Modification 2 of Redfern Mixed Use Co-Living Housing Development

State Significant Development Modification Assessment Report (SSD-32275057-Mod-2)

June 2026

PROJECT NO:
21022
SCALE: 1:200 @A3
PLOTTED: 23/4/2026
DRAWING NO:
SSD2400
REV: **F**

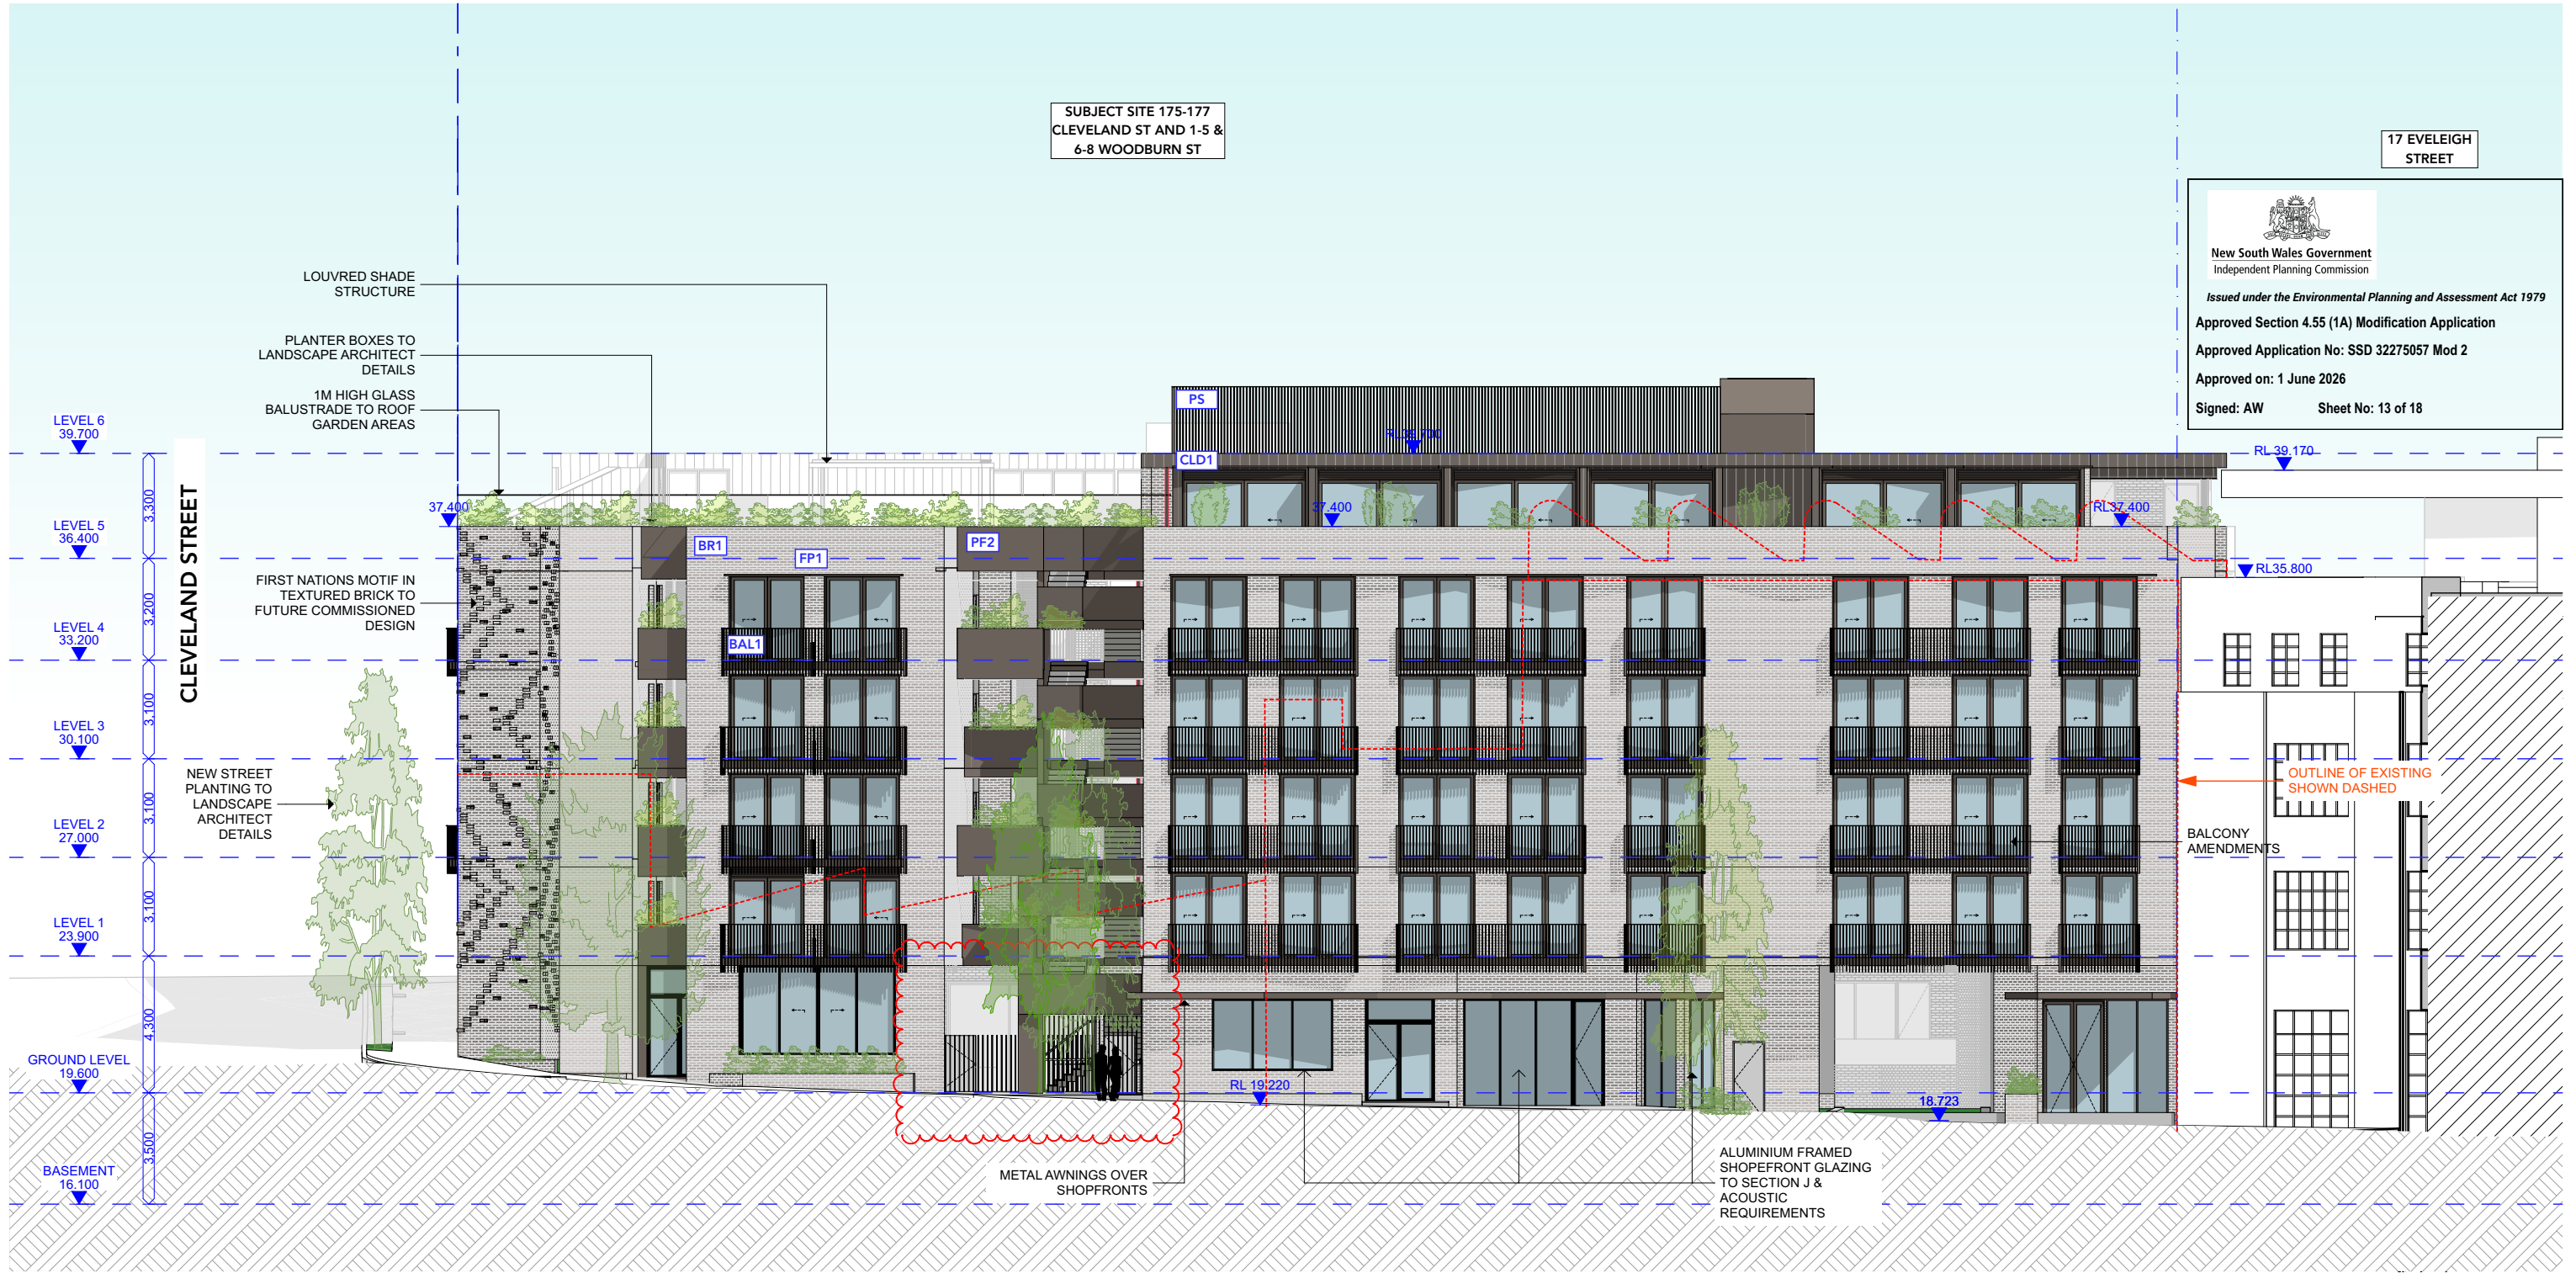
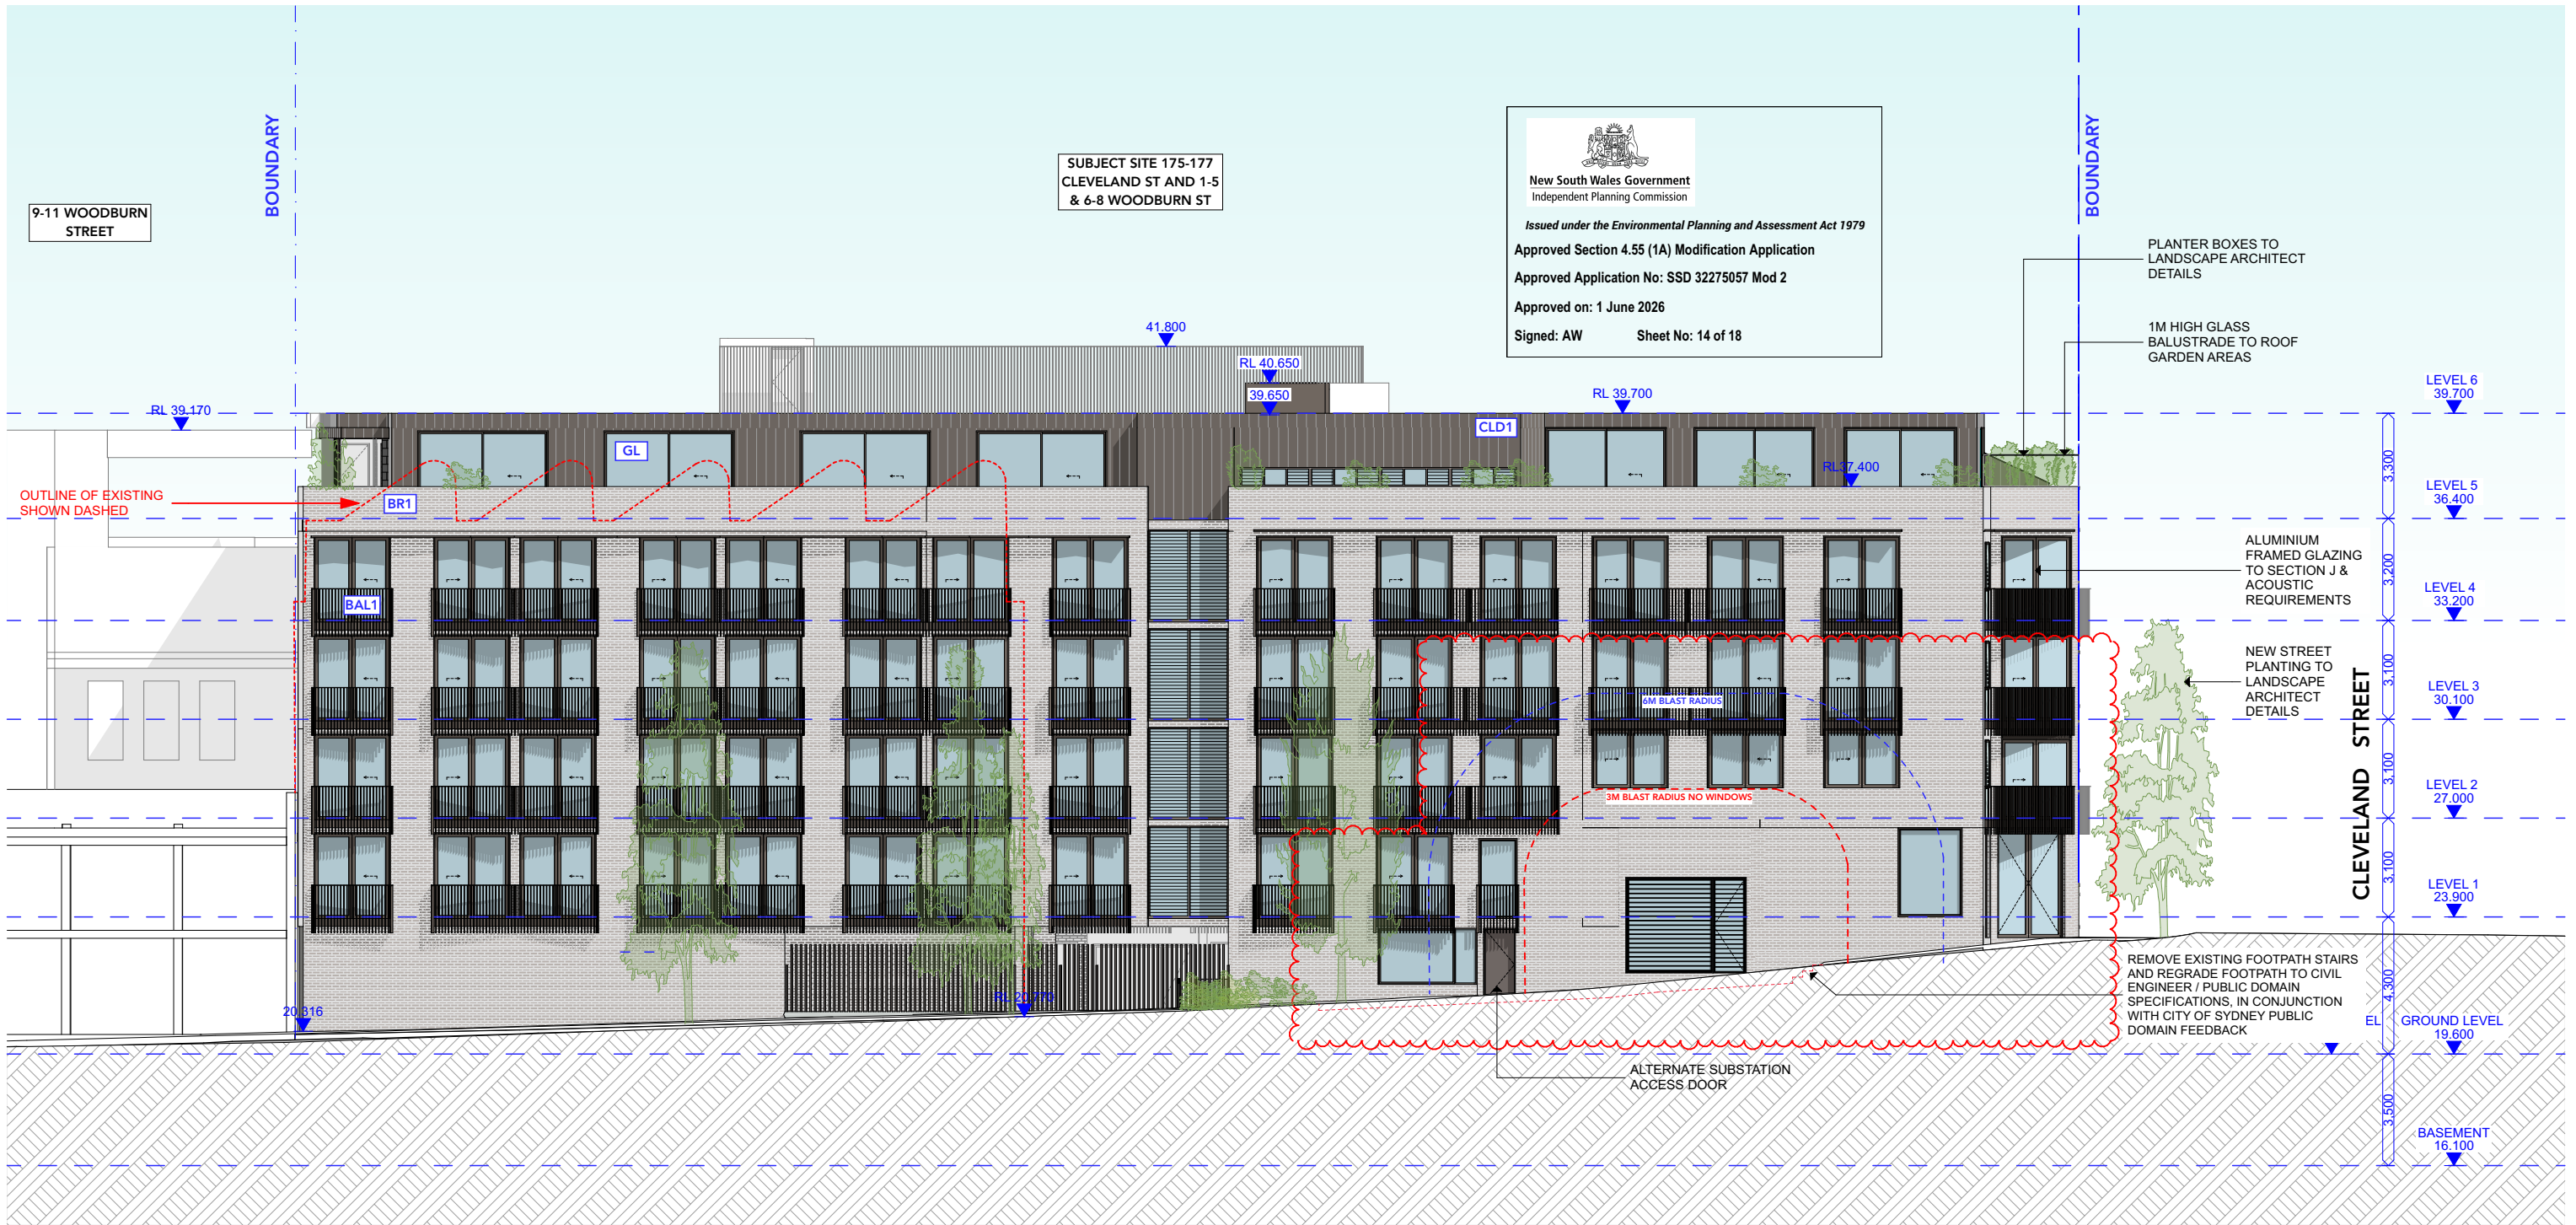
- proposed “co-working space” replacing approved commercial tenancy unit and proposed reception area replacing approved community multipurpose room
 - removal of windows along Woodburn Street, adjacent to public domain and relocation of hydrant booster along Cleveland Street frontage

Council noted that the following modifications result in poorer streetscape outcome, limit street activation and reduced public domain outlook for the approved development, noting reduction in glazing/deletion of windows and relocation of services and access.

In response, the Applicant submitted amended plans showing windows along Cleveland Street and Woodburn Street have been reinstated, except for those that will result in non-compliances with the electrical substation safety requirements. The Applicant noted that the hydrant booster is in a compliant location and will not impact the Level 1 windows or the streetscape.

The Department has carefully reviewed the proposed modifications in the context of streetscape presentation and street frontage activation and notes that the amended proposal appropriately addressed Council's concerns and is acceptable because:
